Rezoning Petition Review

Date of Review: August 21, 2017 ***(Revised April 19, 2021)***

Rezoning Petition #: 17-118

Location of Property: Approximately 0.78 acres located at the northwest corner at the intersection of Statesville Road and Cindy Lane.

DATE: 04/12/21  
FILE: MHP/PL  
DRAWN BY: RST  
REVISED:  
JOB NO: \_\_\_\_\_  
SHEET: **RZ-1**  
OF: \_\_\_\_\_

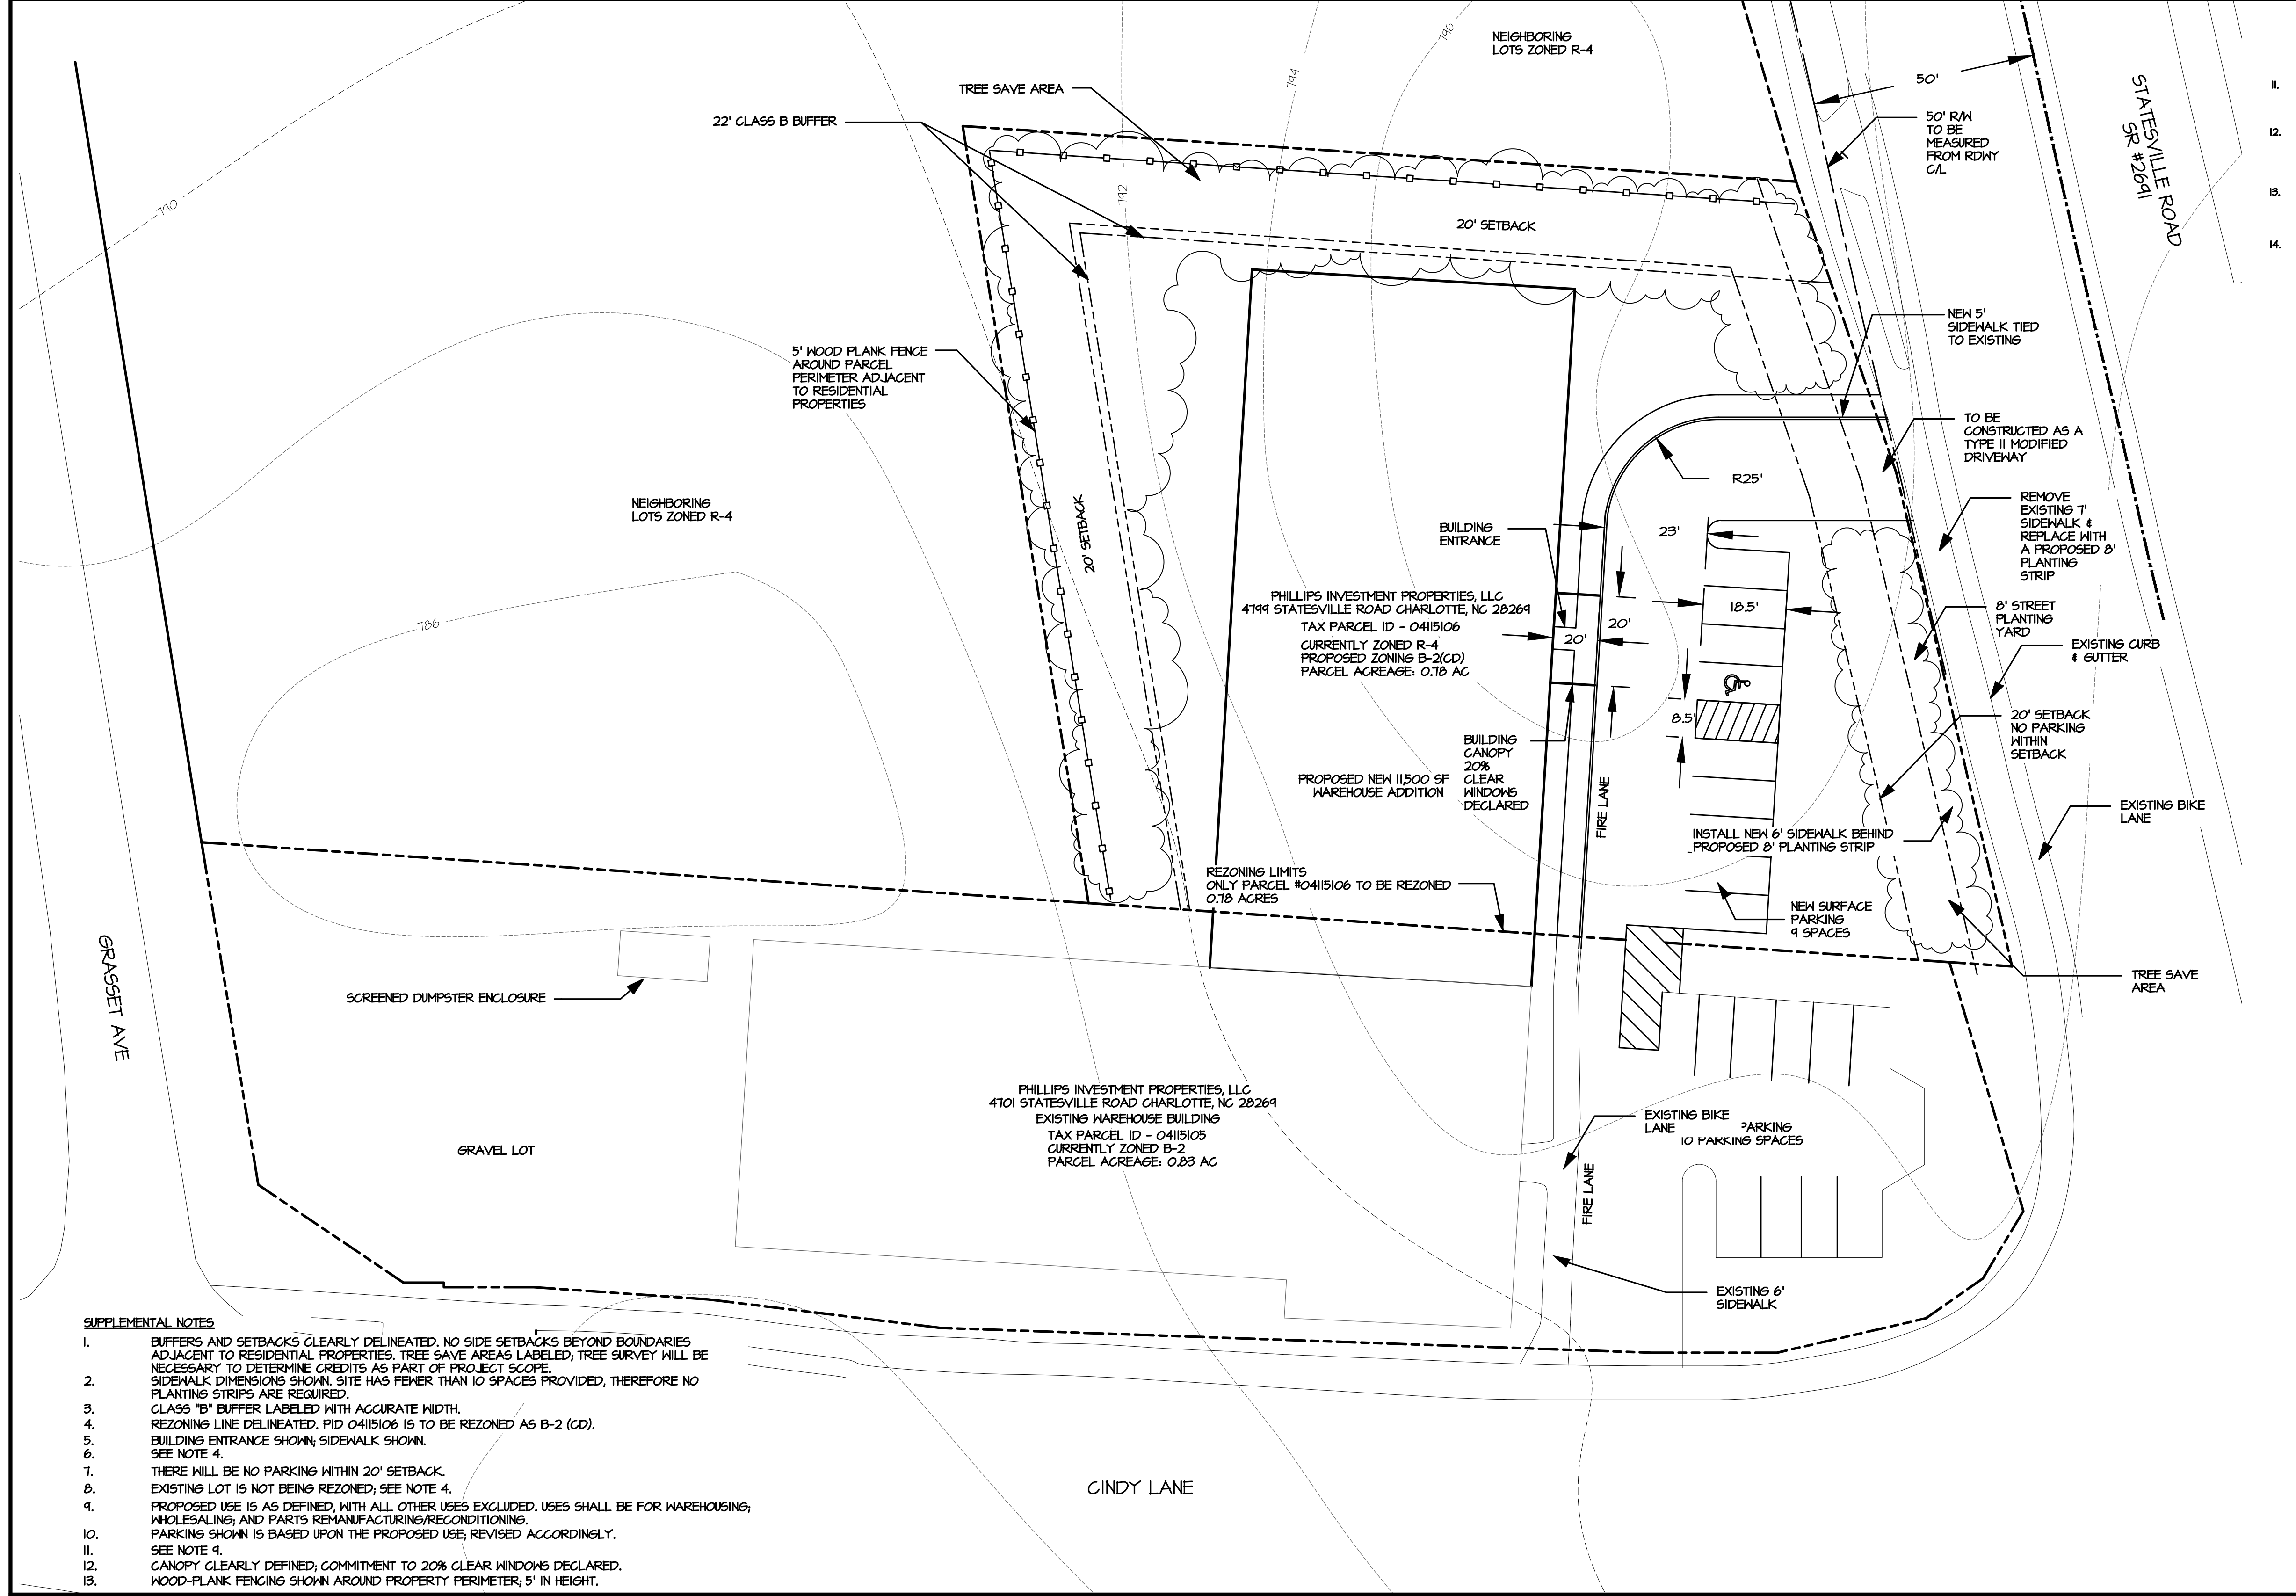
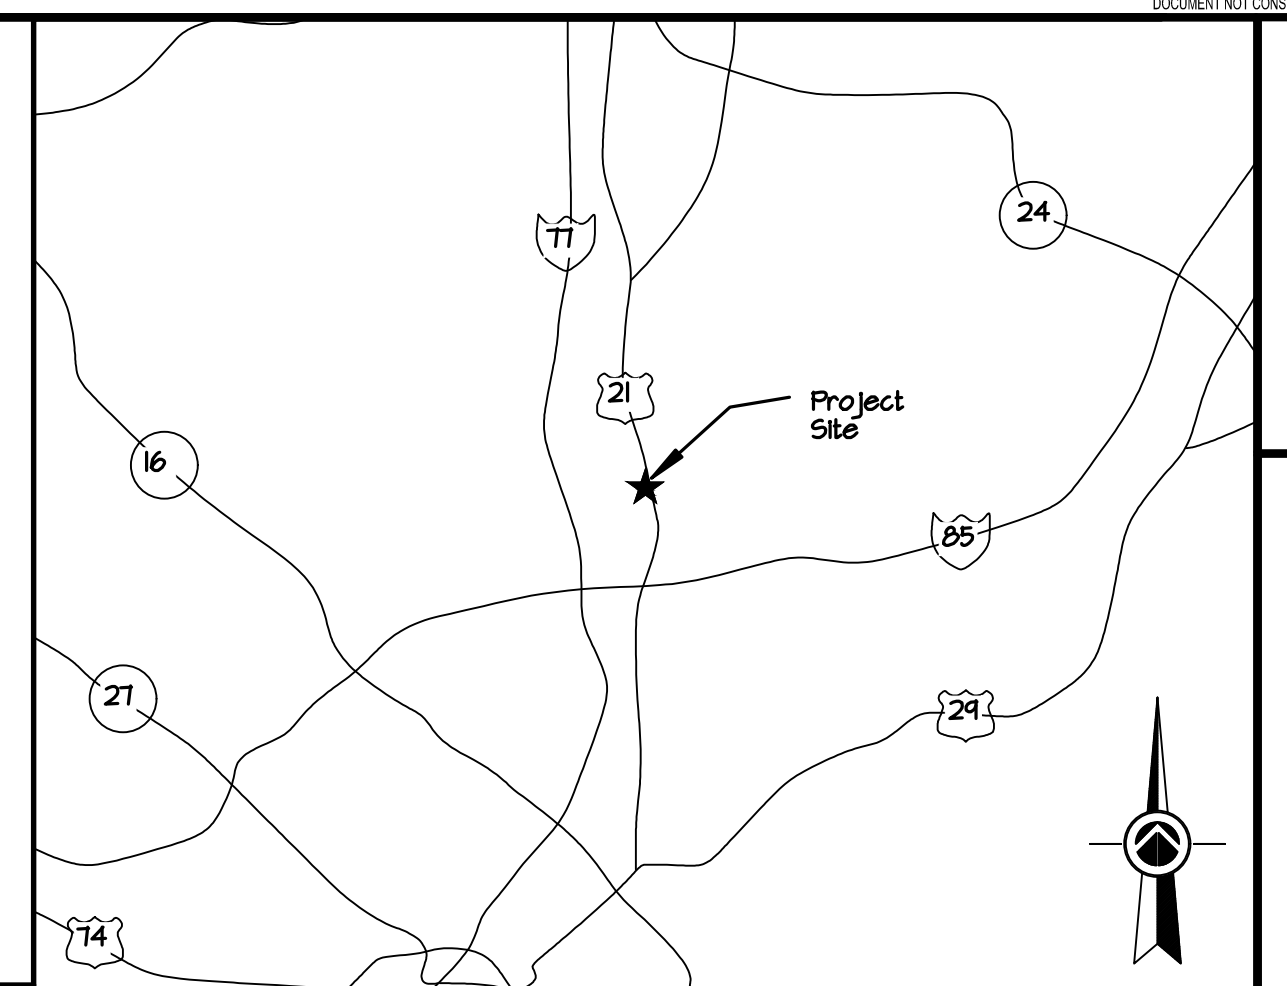
Due to revisions (4/19/21): No additional recommendations are needed at this time.

DATE: 01/11/21
FILE: M21014
DRAWN BY: RST
REVISED:
JOB NO: _____
SHEET: RZ-1
OF: _____

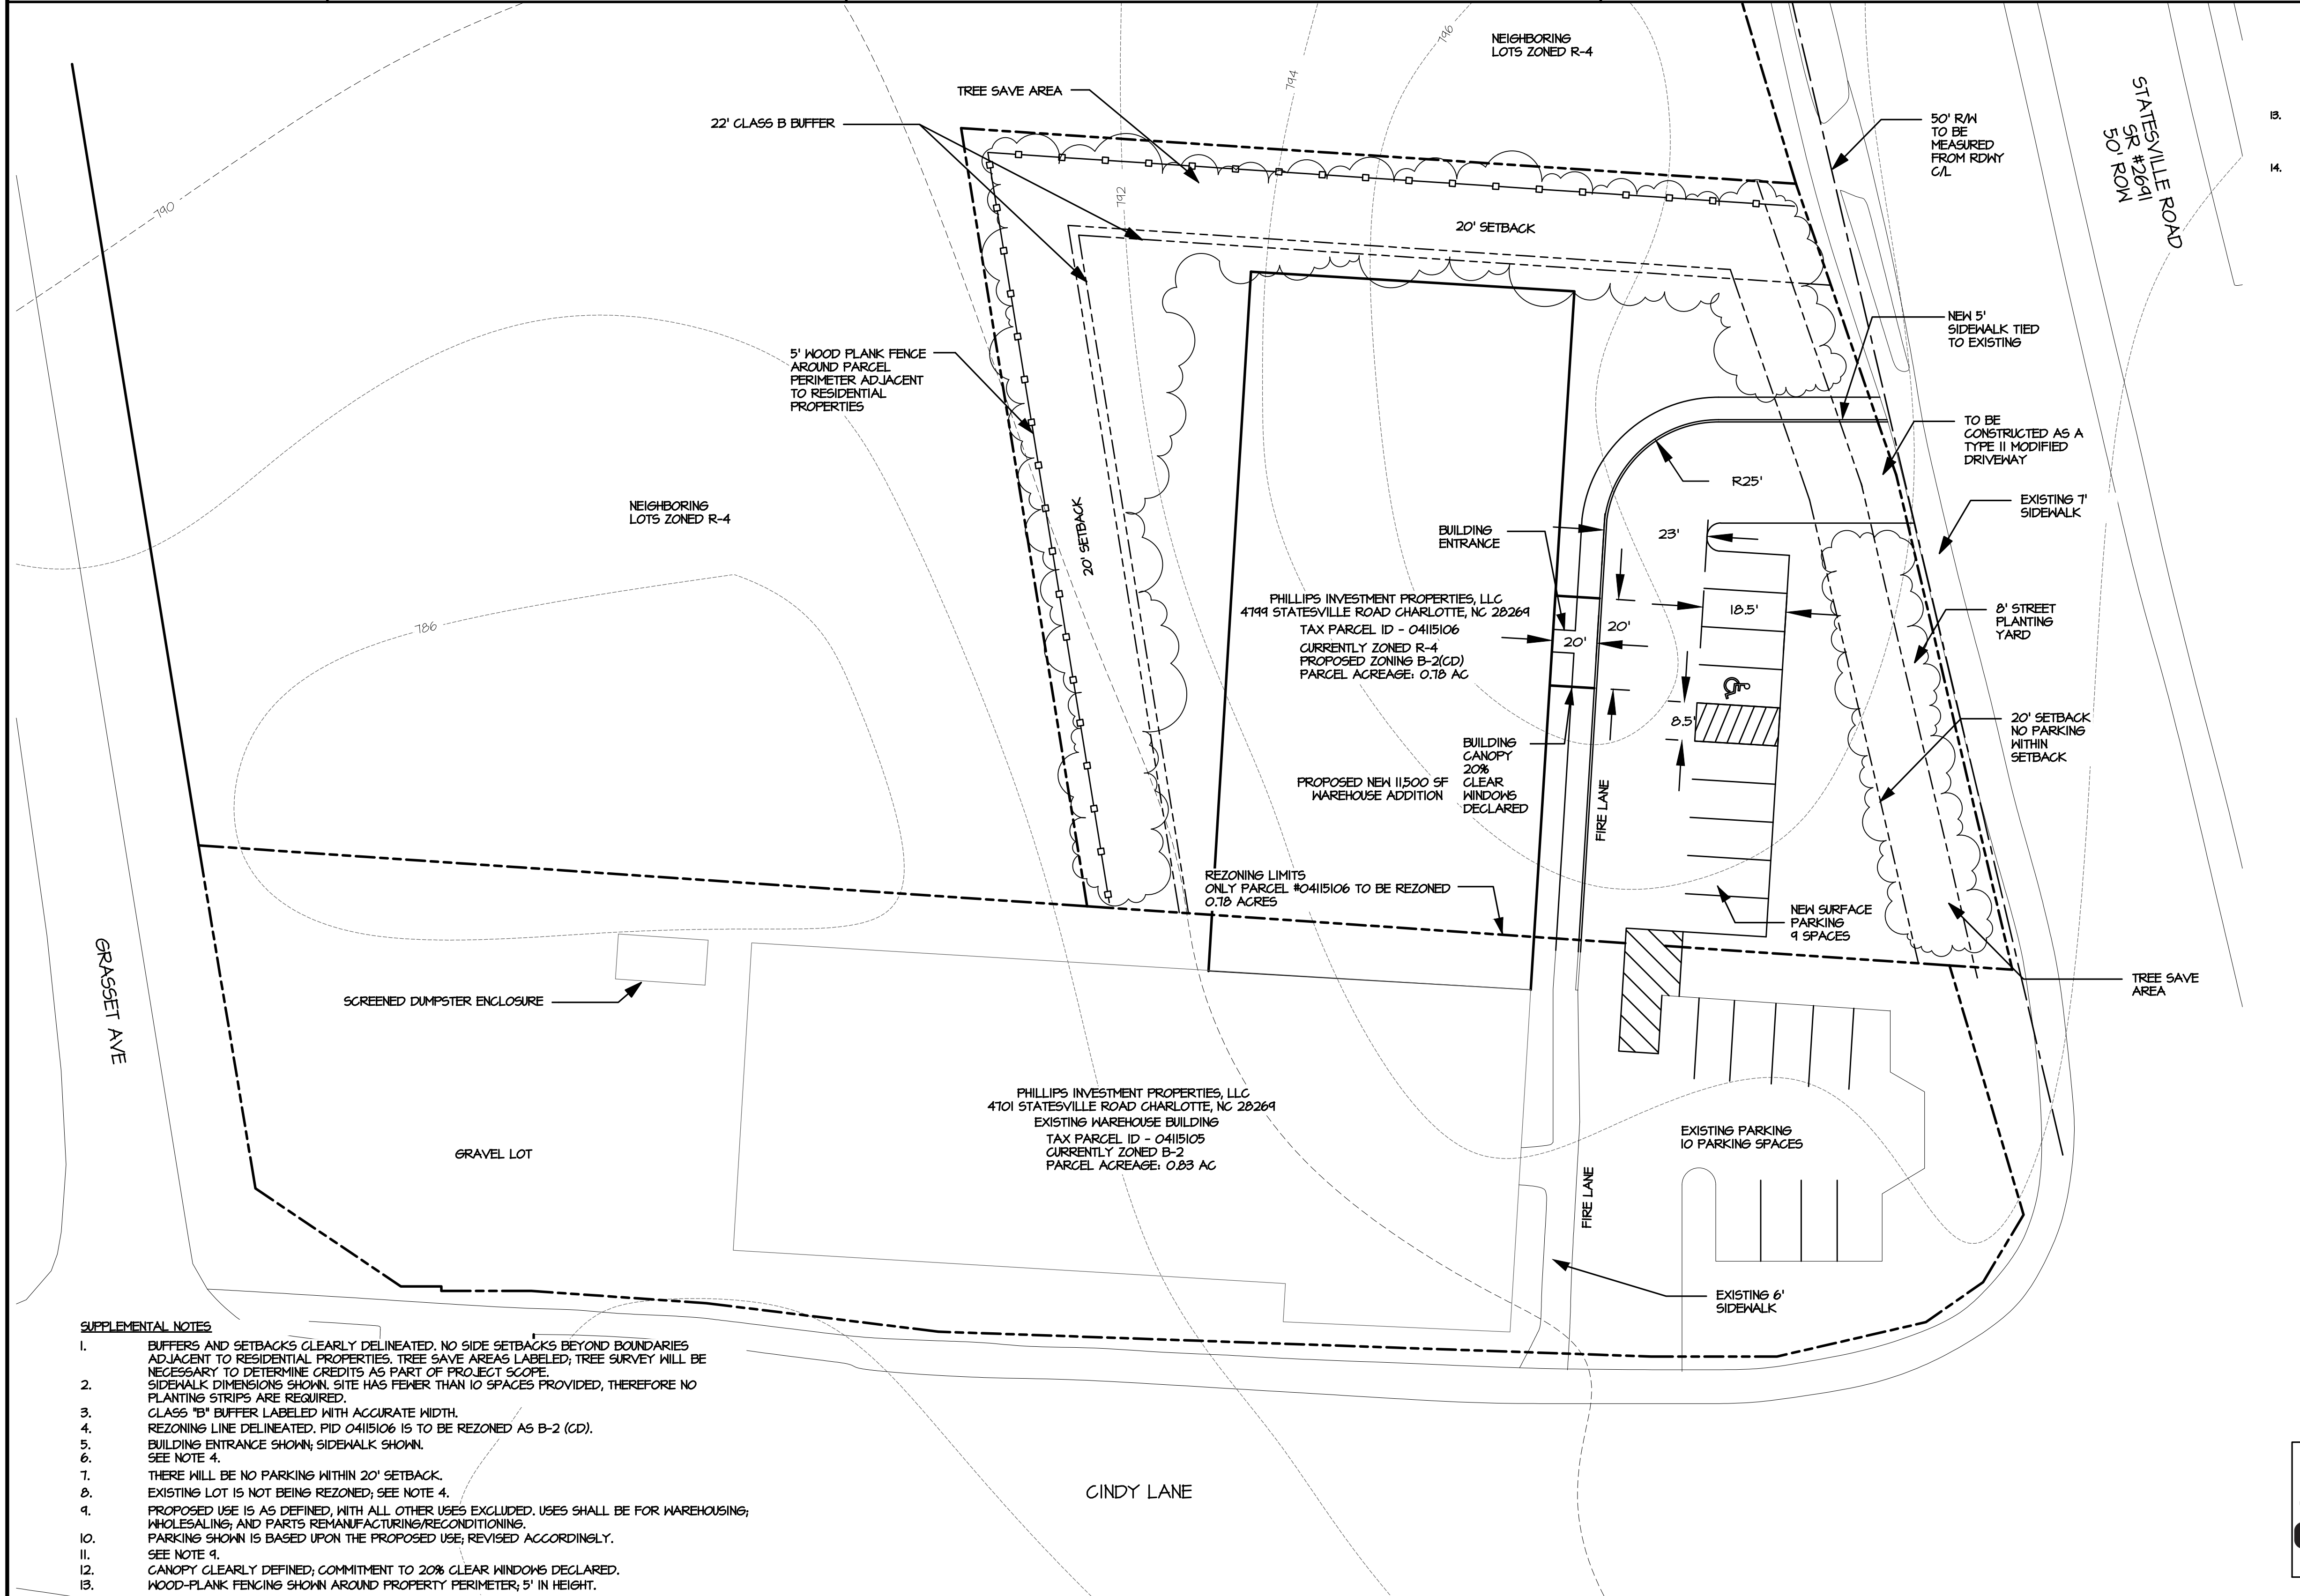
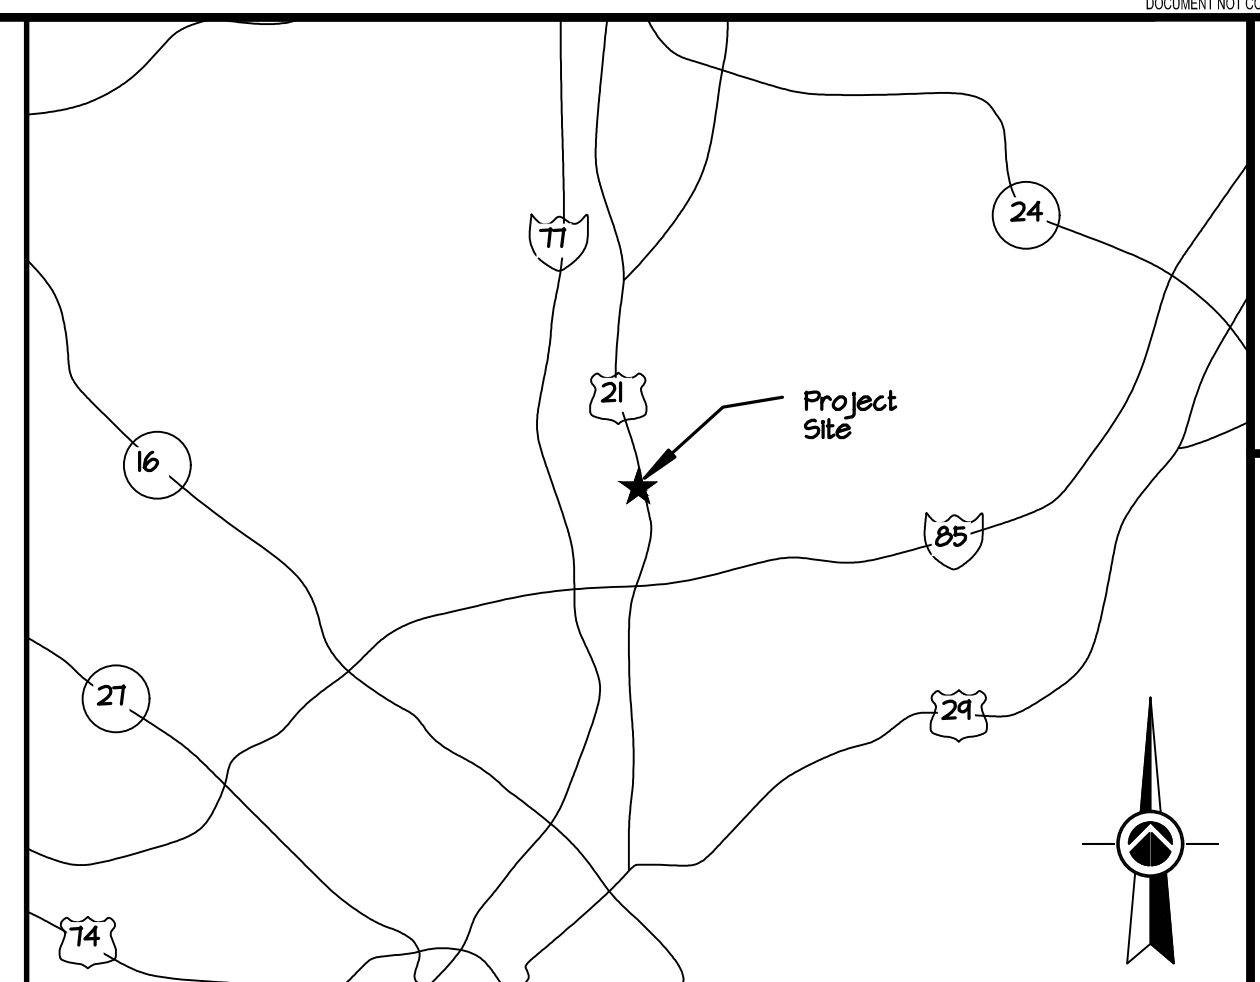
Please remove note 8b in its entirety and replace with the following:
"The petitioner shall comply with the Charlotte City Council approved and adopted Post Construction Stormwater Ordinance."
